**Subject:** Rezoning Petition Review

**Date of Review:** April 28, 2022 (*Revised May 25, 2022*)

**Rezoning Petition #:** 21-264

**Location of Property:** Approximately 4.7 acres located on the north side of Oak Dr, east of Old Statesville Rd and south of Pete Brown Rd.

SHEET DESCRIPTION: CONDITIONAL USE PLAN
 C-1

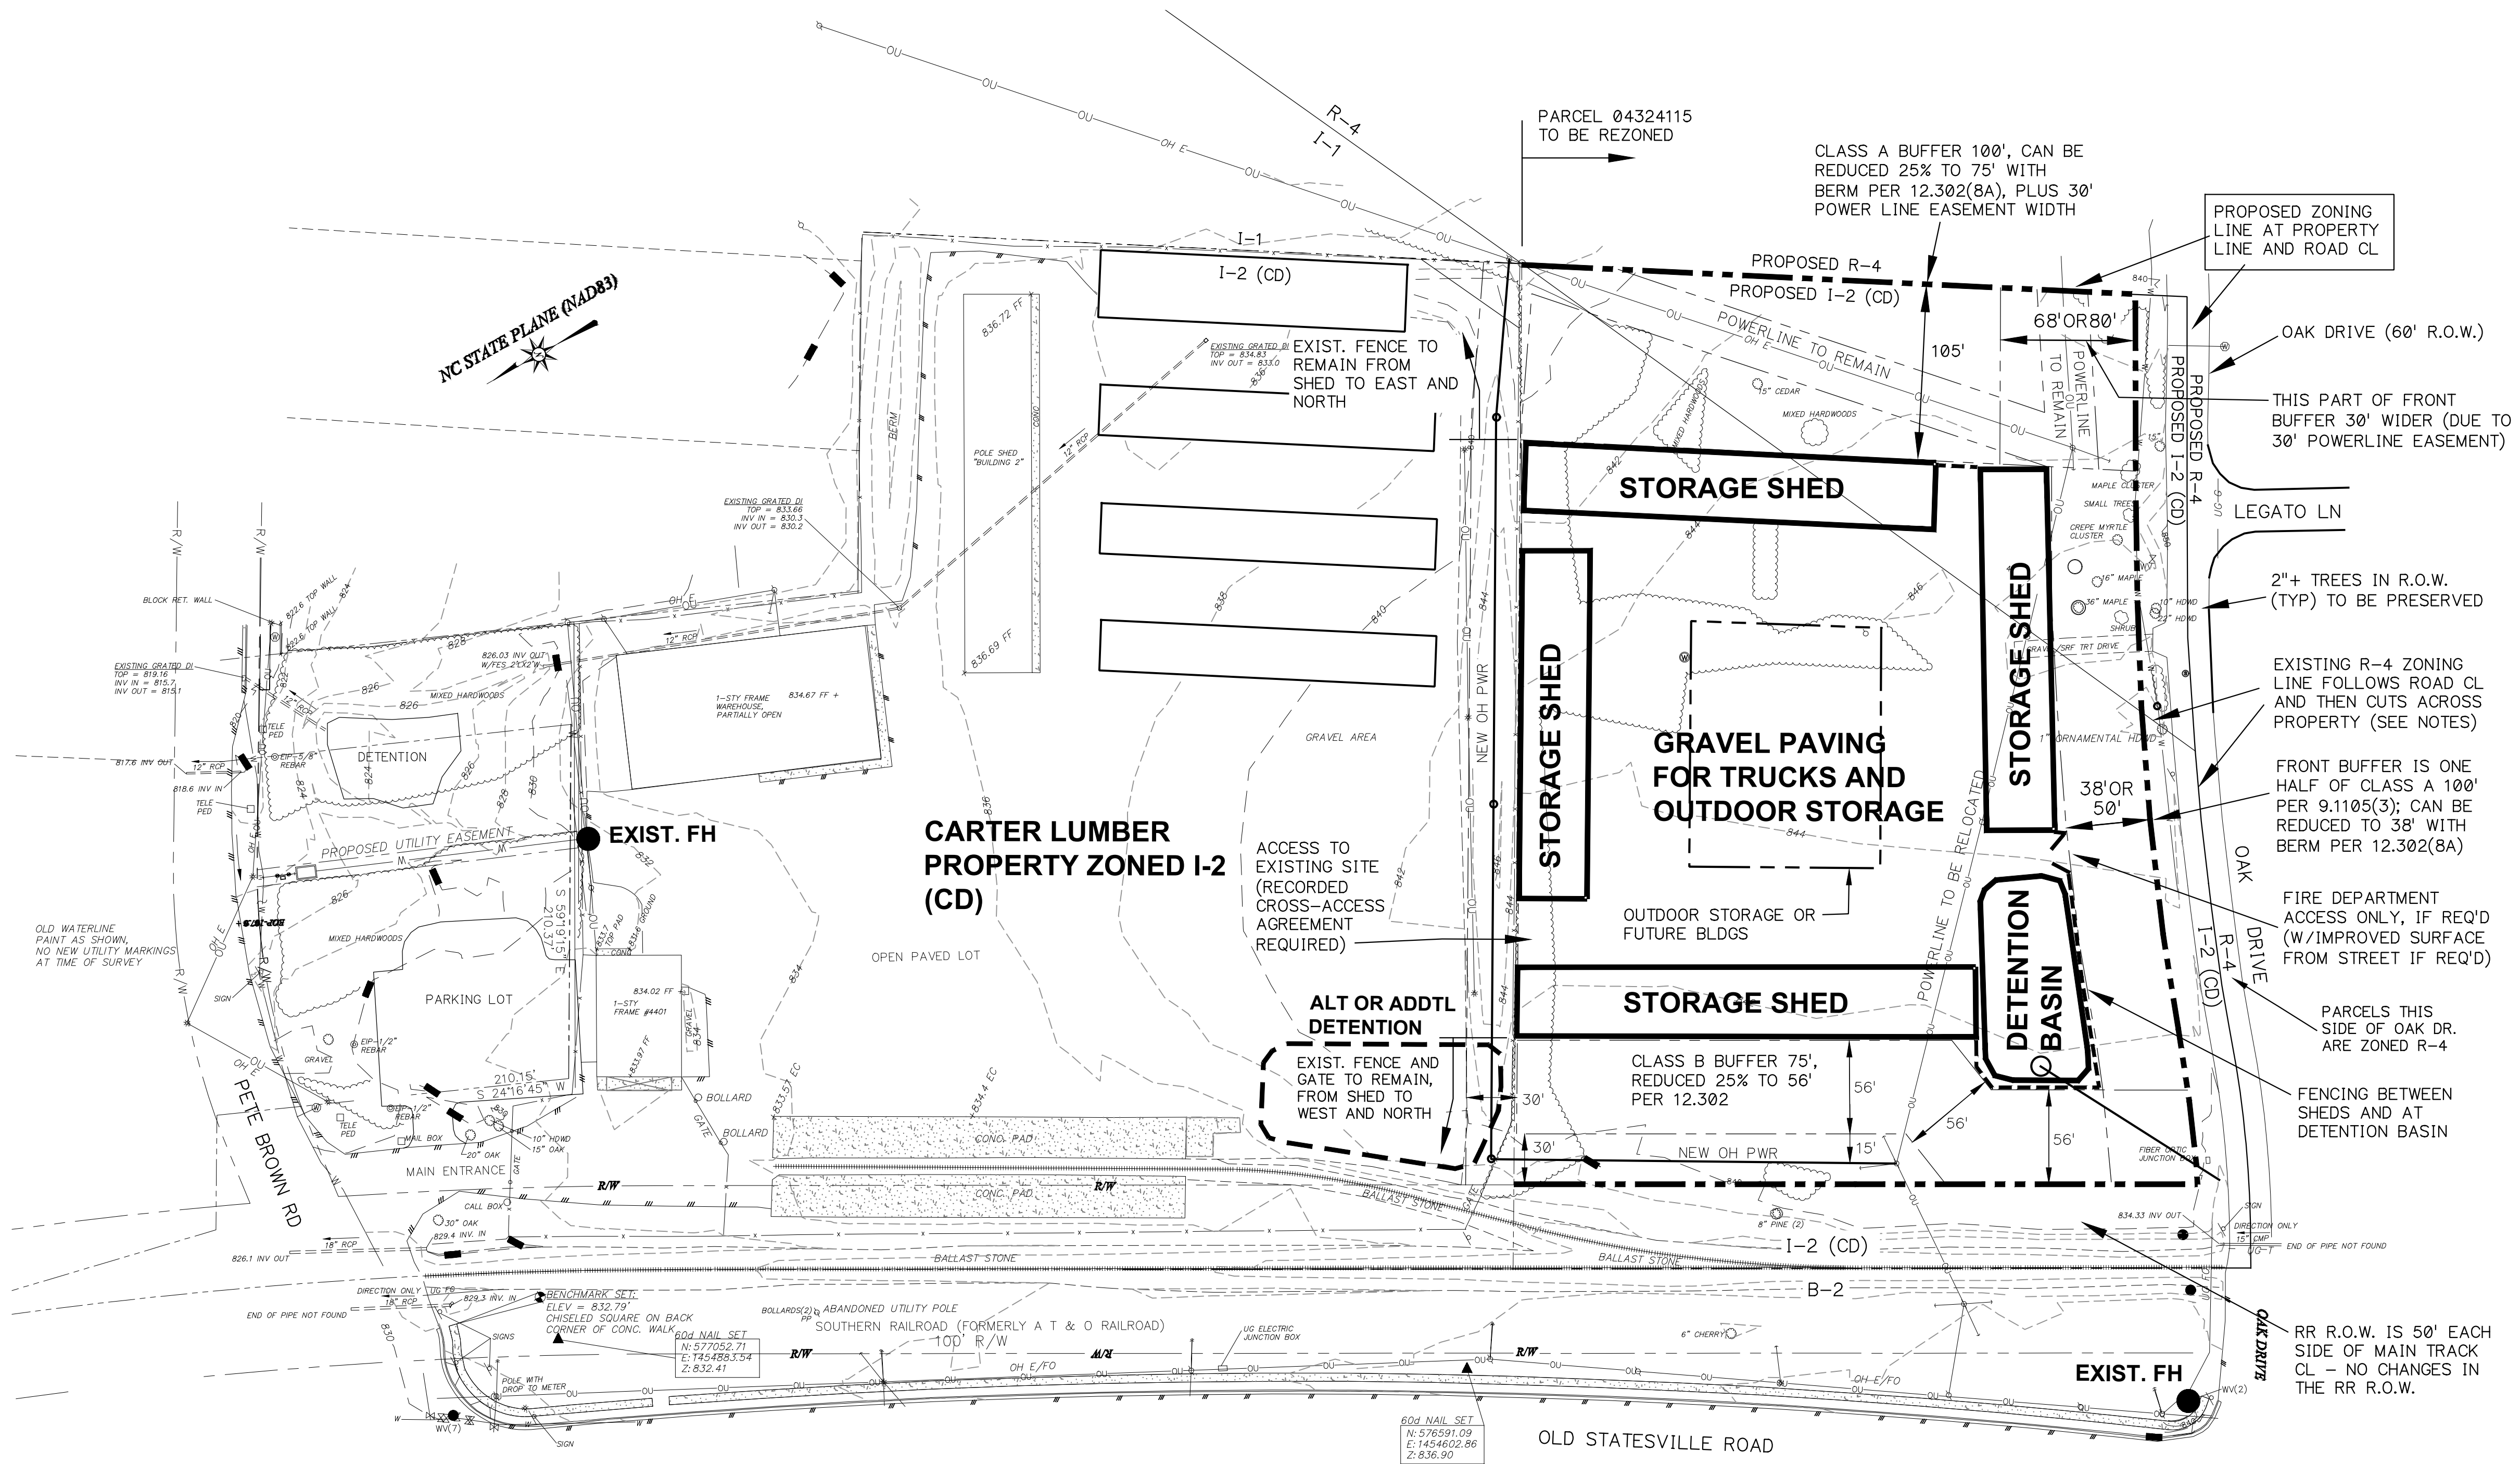
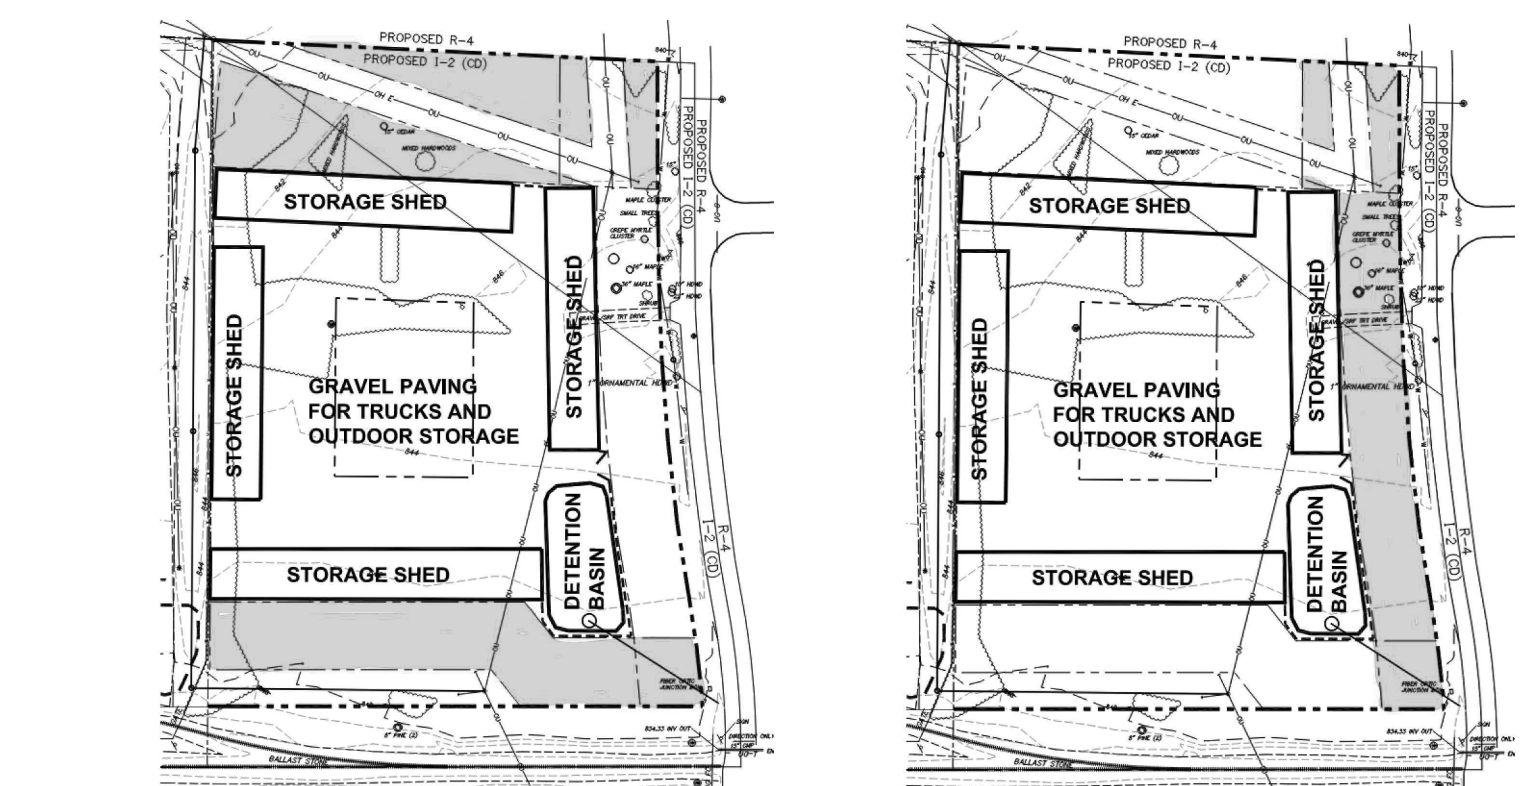
The proposed rezoning plan sheet indicates a proposed location for storm water management. Please include the following notes on the plan sheet under "Environmental Features": *The location, size, and type of storm water management systems depicted on the Rezoning Plan are subject to review and approval as part of the full development plan submittal and are not implicitly approved with this rezoning. Adjustments may be necessary in order to accommodate actual storm water treatment requirements and natural site discharge points.*
